From: [Taylor Gustafson](#)
To: ["Cruse & Associates"](#)
Cc: [Dusty Pilkington](#); [Lindsey Ozbolt](#); [Chuck Clark](#)
Subject: FW: BL-18-00008 Clark
Date: Tuesday, July 03, 2018 9:18:22 AM

From: [Dusty Pilkington](#)
Sent: Tuesday, June 26, 2018 4:53 PM
To: 'Cruse & Associates'
Cc: [Lindsey Ozbolt](#)
Subject: BL-18-00008 Clark

CLARK PROPERTY

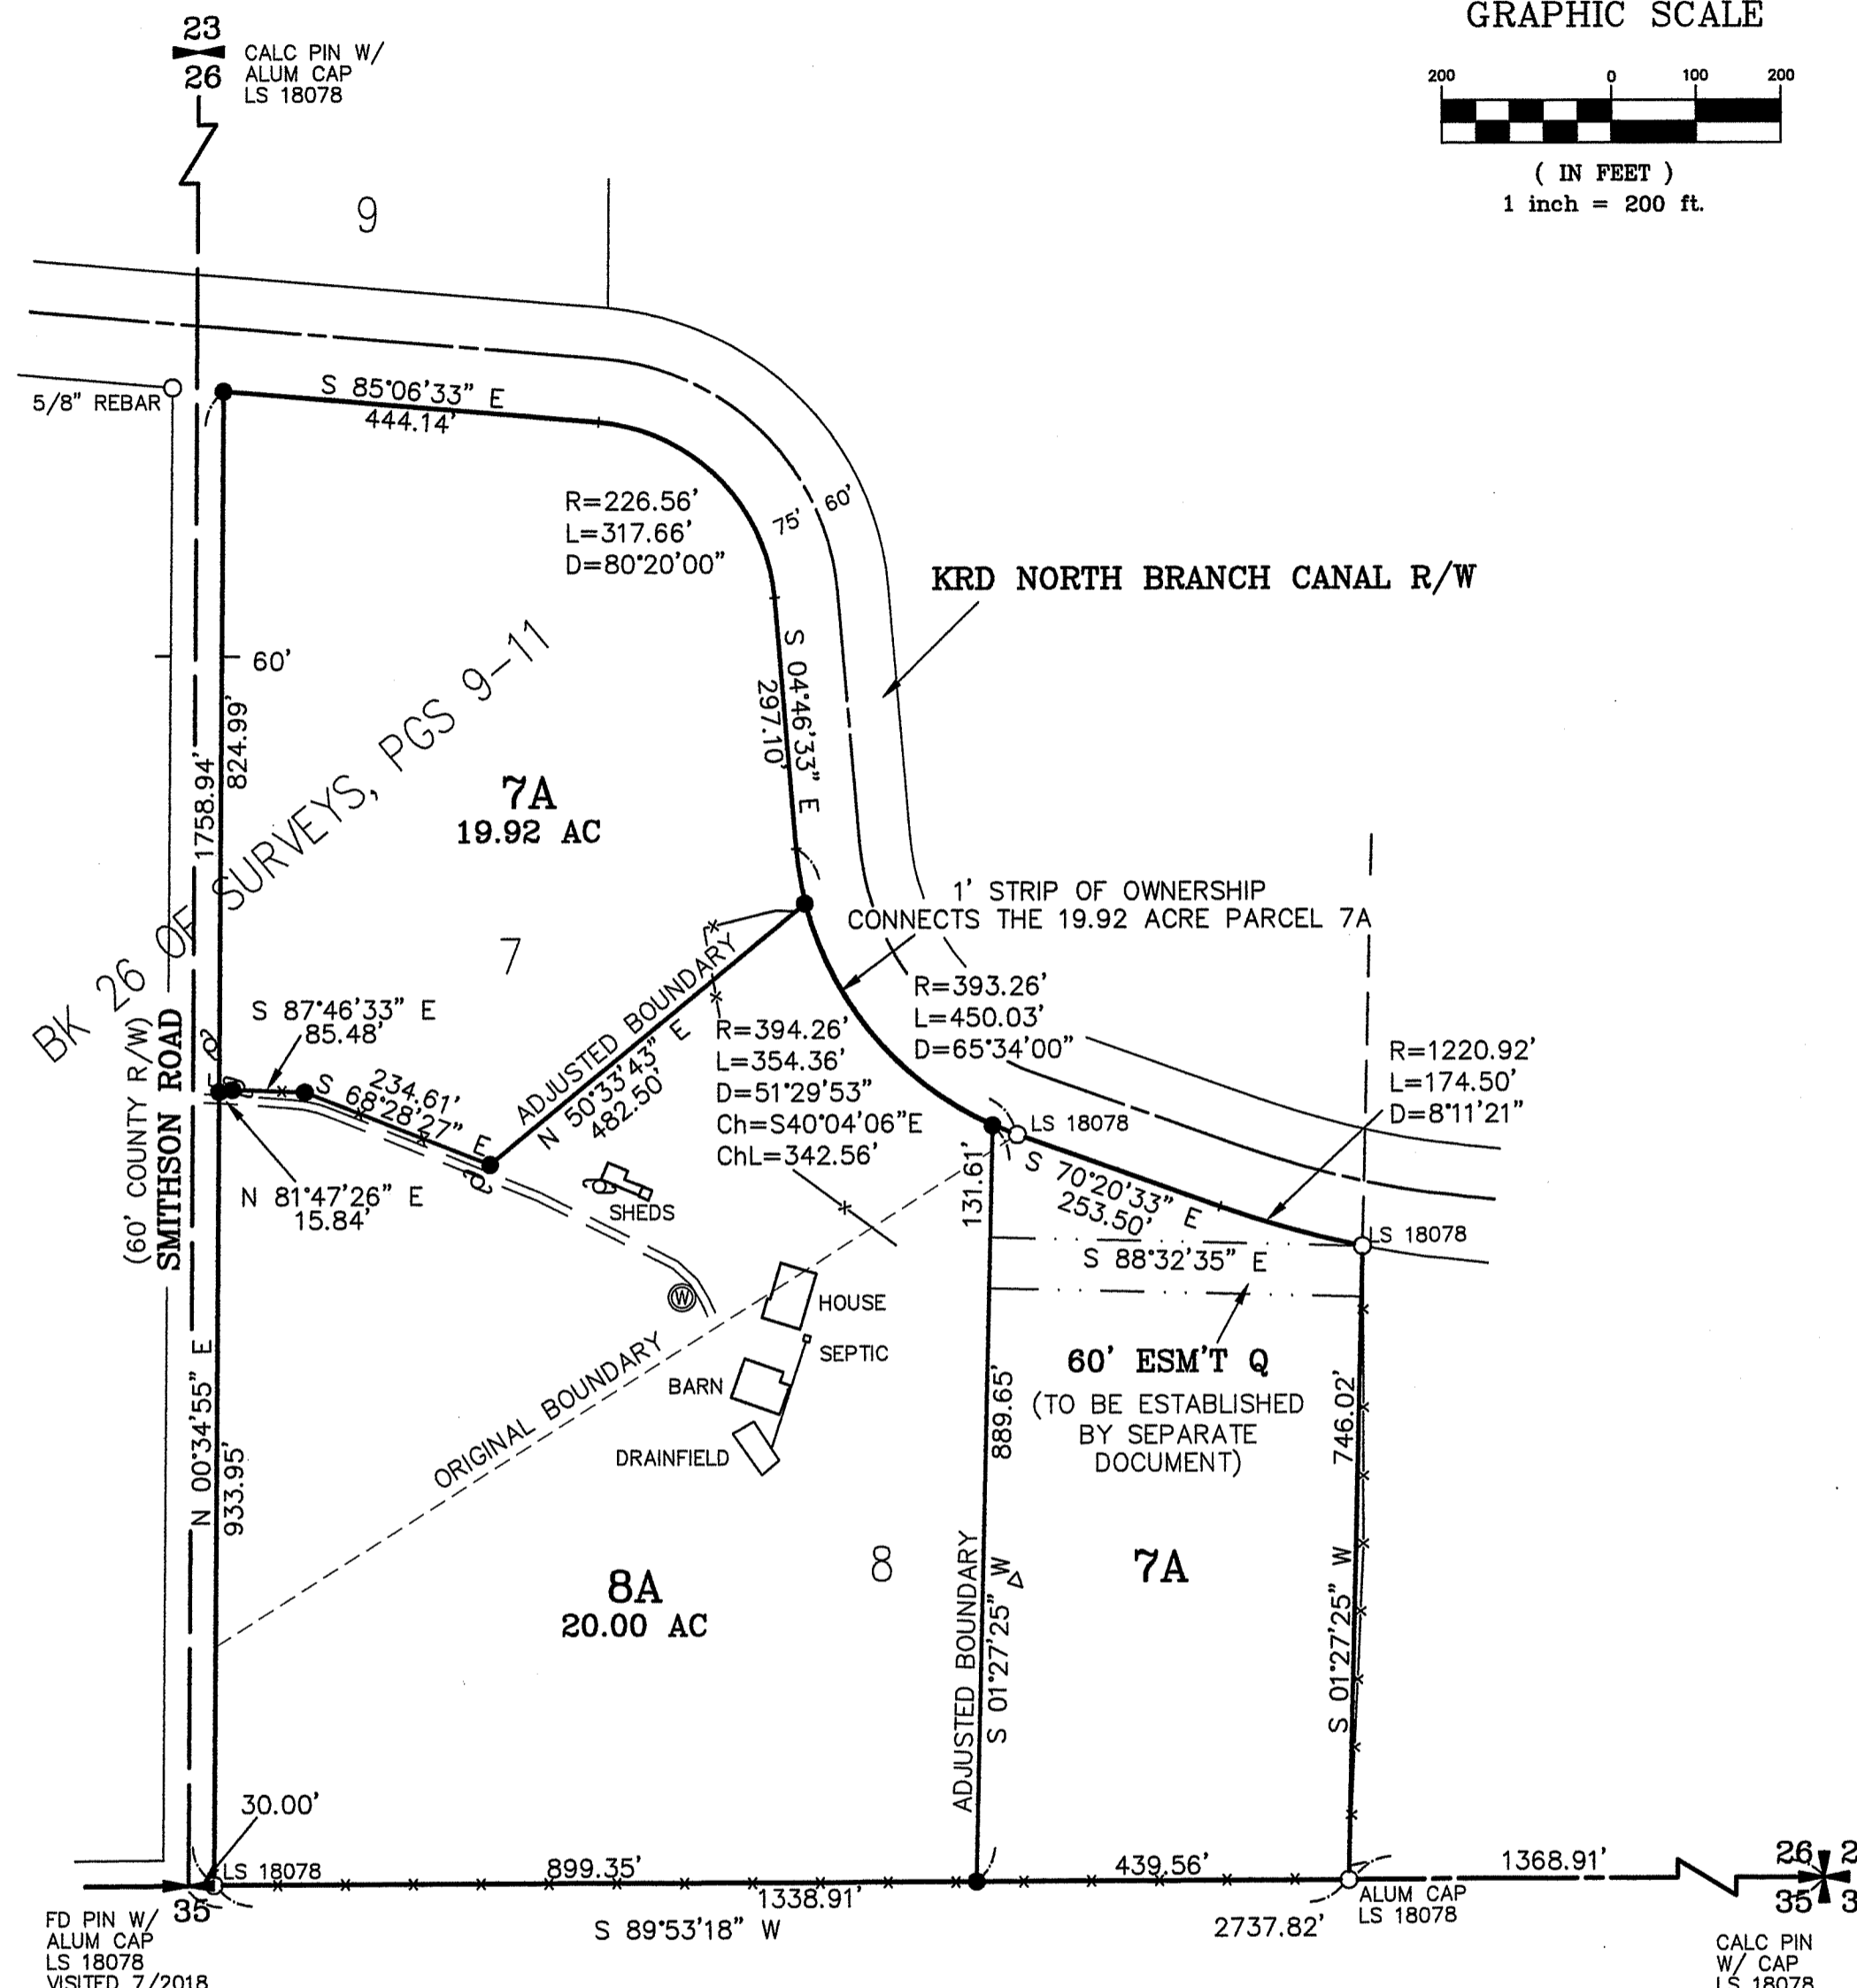
Dusty – There is access to the buildable portion of Lot 2 that fronts Smithson road. It was our intent to not allow access to the back half of lot 2 as the previously owner discussed with KCCDS before we submitted. Our layout meets all county code as I interpret it, can you please point out the code that requires us to provide access to the entire property.

I have spoken with Mark in regards to the BLA and we will not require the applicant to address the access issue to the back half of the property.
